Please ask for: Kathryn Welch
Email: kathryn.welch@arun.gov.uk
Telephone: 01903 737789
Our Ref: M/12/21/T
Your Ref:
Date: 26th February 2021

Application for Works to Trees(s) subject to a Tree Preservation Order(TPO)

Development: Remove limbs to 2 No. Sycamores (T1 and T2) to westerly face.
Location: 14 Sunnymead Close Ancton Middleton-On-Sea PO22 6LS

Location of the two
Sycamores.

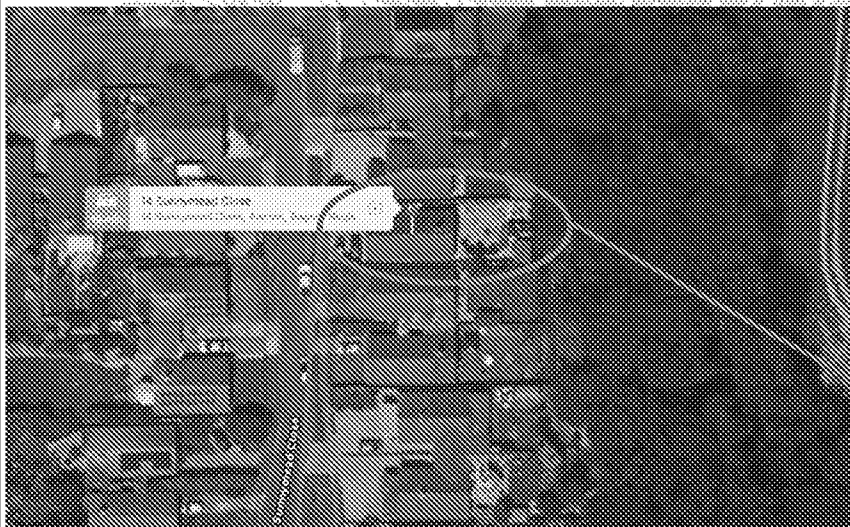
Please provide proposed height measurement (m) of canopies from ground level of T1 and T2 to westerly faces.
